SSI - 5414 - North West Rail Link EIS 2

2 Indicative Layout – Bella Vista Station Precinct

RE: McDONALD'S, BELLA VISTA

Figure 7 Bella Vista station – heavy vehicle routes

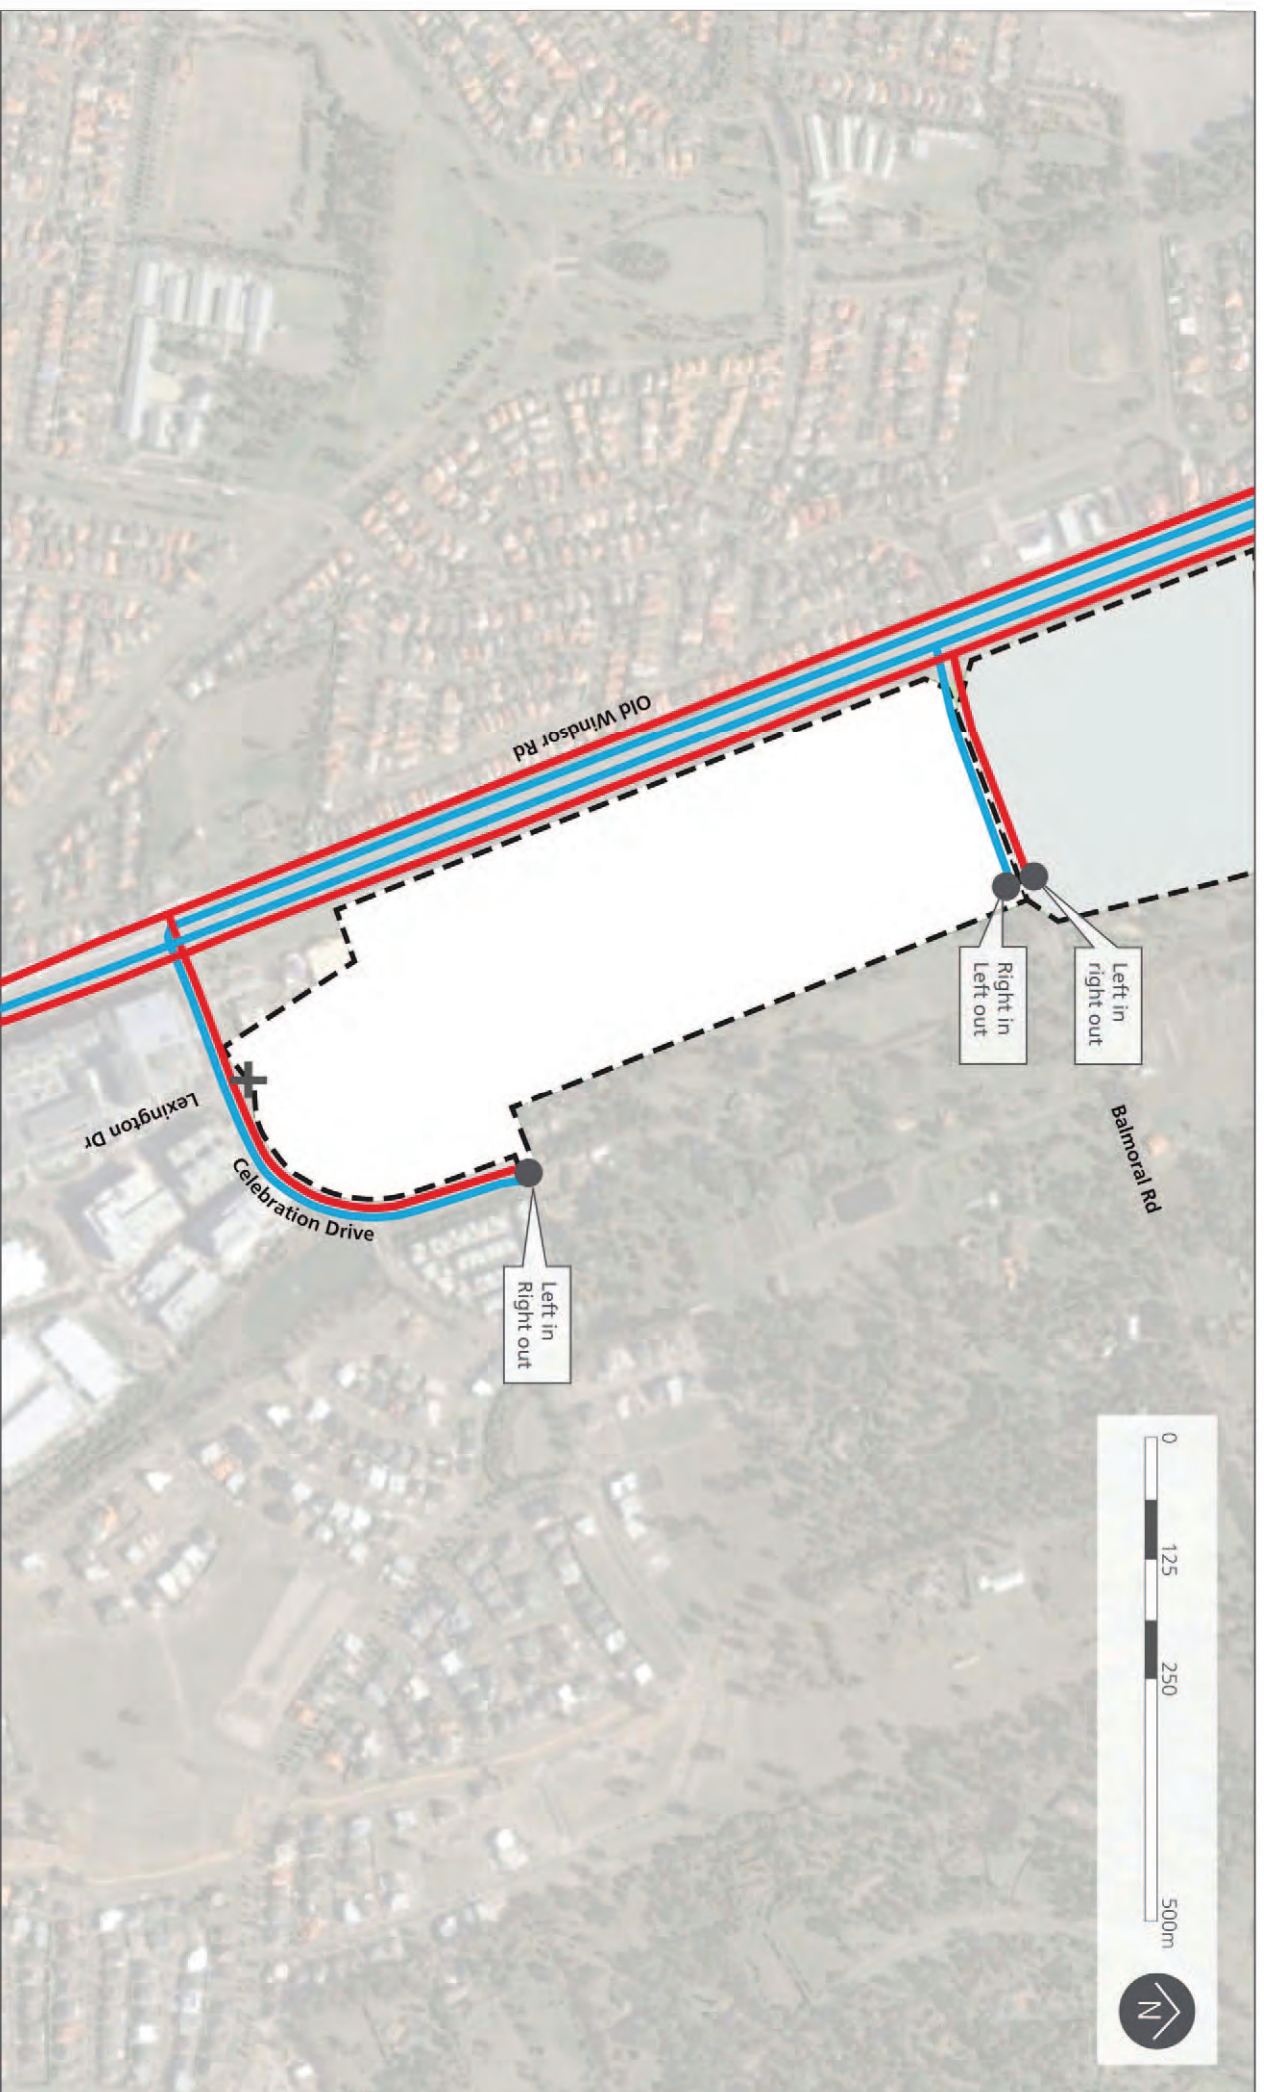
- Noise
- Dust
- Construction traffic
- Like EIS 1 however, the NWRL approach is to again defer precise mitigation responses to the implementation stage, via the "*Construction Environmental management Framework*". This approach does not address uncertainty for McDonald's know, particularly when at a higher level the proposed station precinct layout delivers a sub-optimal outcome for on-going store operations.
- We therefore consider it essential that these impacts be accurately assessed now, and that detailed mitigation responses be developed now in consultation with affected landowners including McDonald's.

Figure 6.27 Bella Vista Station - Indicative layout

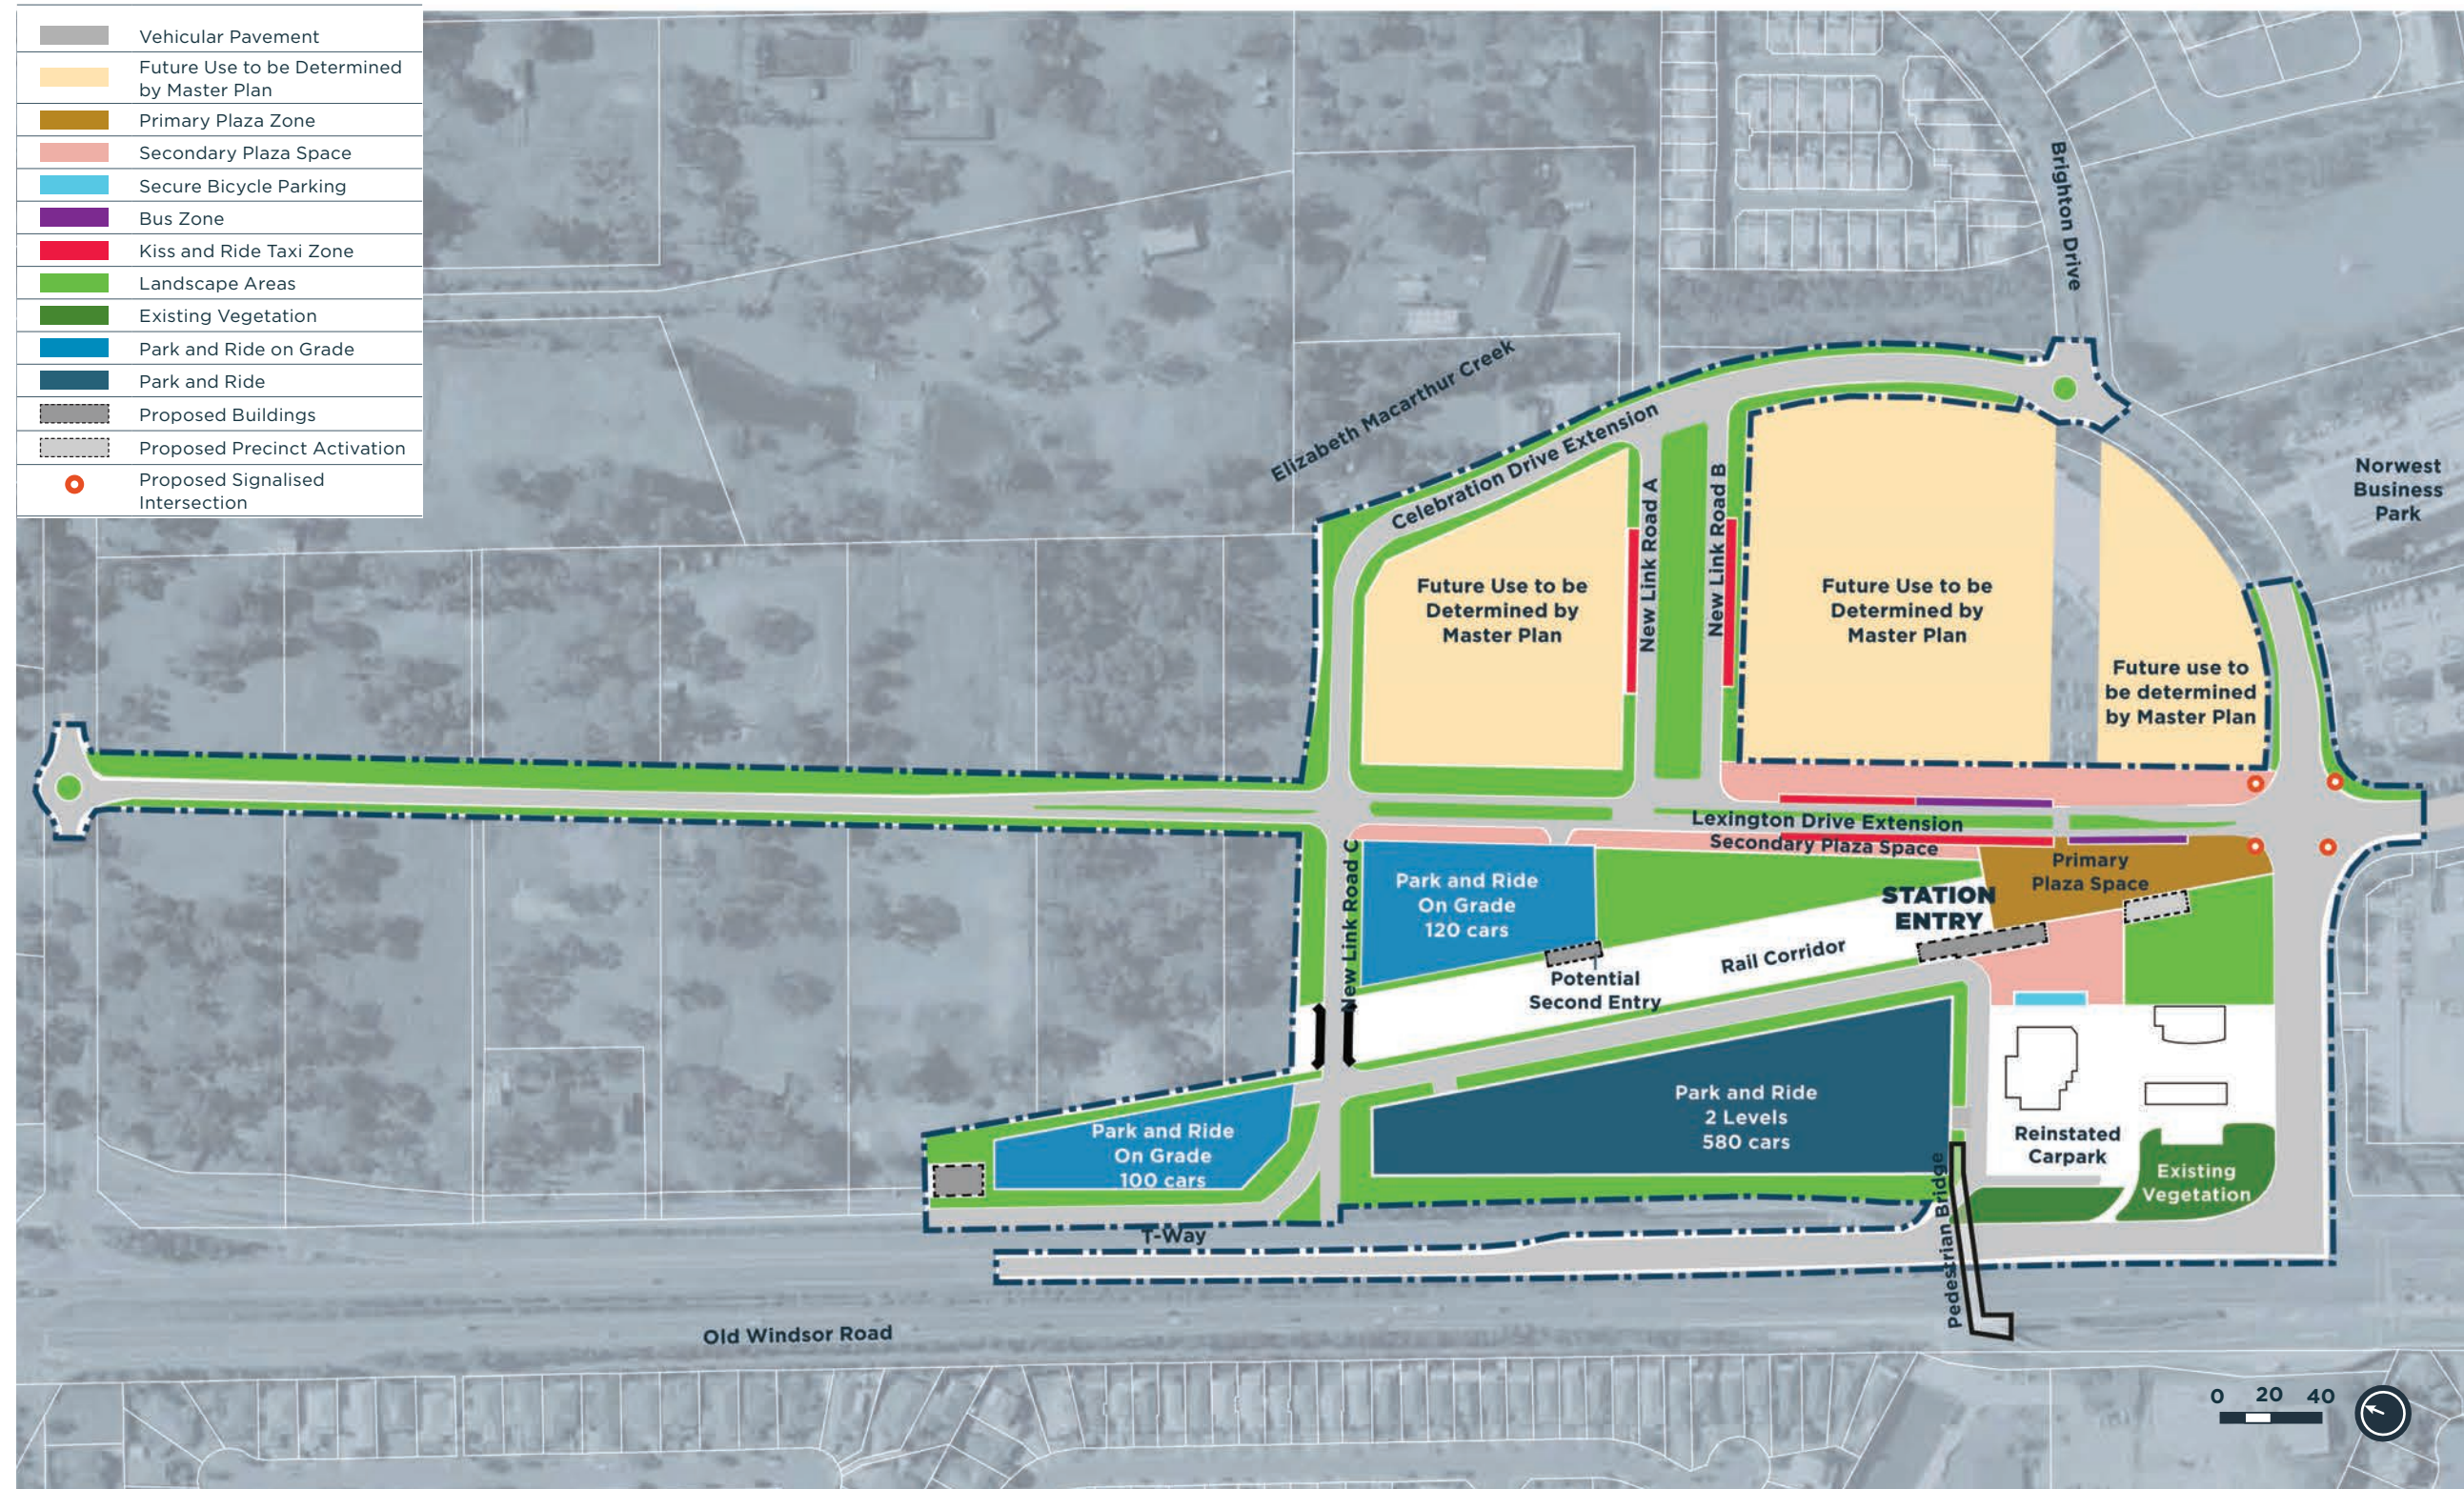
This submission focuses on Figures 6.27 and 6.26 contained in EIS 2 that respectively detail an indicative layout plan for the Bella Vista Station Precinct and an indicative vehicle and pedestrian movements plan for the Precinct. Our review of these drawings allows an assessment of impact on the longer term operations of the McDonald's restaurant which are as follows.

Figures 1 and 2 below illustrate the practical impact of entry and exit to the McDonald's outlet from the proposed layout for the Bella Vista Station precinct. Whilst the new slip lane entry into the site from Old Windsor Road is acknowledged, this must be balanced against:

- The practical ability for this slip lane to be constructed due to the alignment of the existing T-Way underpass; and

- It's effectiveness for McDonald's given that it is also providing primary access to an adjoining 800 car space park and ride facility. There is no detailed modelling or analysis within EIS 2 that give McDonald's any comfort that this is practical given the close proximity (circa 30m) that separates the entry to Park and Ride and entrance to the reinstated McDonald's car park.
- The circuitous route that trade originating from the residential area to the east must traverse as compared to the existing situation via Brighton Drive/Celebration Drive.

In contrast the proposed exit from the site is unacceptable and quite simply hasn't been given any thought at all. The key business driver for a McDonald's store is convenience. This is reflected for example in drive through trade generating a significant proportion of McDonald's store turnover in a typical operation. As the name suggests a drive through must be

The proposed “reinstated car park” depicted on Figure 6.27 compromises each of the key design principles outlined above. In summary, the proposed reinstated car park:

- Positions majority of car parking on the opposite side of the building, remote from the from store entry.
- Positions the drive-through central to the site running between the car park and the restaurant.
- Locates car parking in proximity to the loading dock.
- Gives rise to significantly increased opportunity for vehicle and pedestrian conflict within the McDonald’s site.

Whilst it is acknowledged that Figure 6.27 is “indicative”, it is based on design principles that are fundamentally at odds with the above. The only way by which these could conceivably be addressed is by demolition of the existing restaurant and the complete re-orientation of the building so that it faces west rather than east. This is an unreasonable impost.

McDonald’s currently enjoys a high degree of exposure to passing trade with clear sight lines from south bound traffic on Old Windsor Road. It is considered that the scale and built-form alignment of the proposed park and ride facility, together with the proposed pedestrian bridge will significantly diminish views into the store. Figure 3 earlier in the submission identifies an opportunity to potentially splay the park and ride facility for the purposes of assessing improved access/egress from the site. This issue should be investigated as part of detailed station precinct design. However, the proposed pedestrian bridge, which connects to the existing T-Way station opposite appears to present limited opportunity to allow for design in a manner that mitigates the impact on exposure to the McDonald’s store.

- Relocation of the "reinstated car park" to a location that addresses McDonald's design principles.
- Provision of a road link that provides direct access from the site onto Celebration Drive,

3. Figure 6.27 in EIS 2 shows the indicative layout of proposed Bella Vista Station. It has been designed as a park and ride facility with 800 parking spaces located in a multi-deck car park and at grade car parks. The car parks are located adjacent and north of McDonald's. Land use on the eastern side of the station is shown as subject to a future master plan. EIS 2 indicates that the works for the station would commence in mid-2016 and be completed early 2018.
4. McDonald's forms part of the indicative layout plan with a reconfigured car park located on the western side of the store. Access would be retained from Old Windsor Road (existing) with a new connection to the north. While not shown it is assumed that the existing connection to Celebration Drive (via the adjacent BP service station) would be retained.

5. The EIS indicates that as part the station construction the existing McDonald's car park would be relocated from the eastern side of the store to the western side of the store. Relocating the car park to the west would result in the drive through separating the car park from the store. This would result in safety concerns as customers would have to cross the drive through to access McDonald's from the car park. This is not an optimal arrangement and could result in safety concerns. We also note that relocation of the car park to the west would locate the car park in the existing set back zone from Old Windsor Road. Provision of car parking within this set back zone may not comply with Council planning controls.
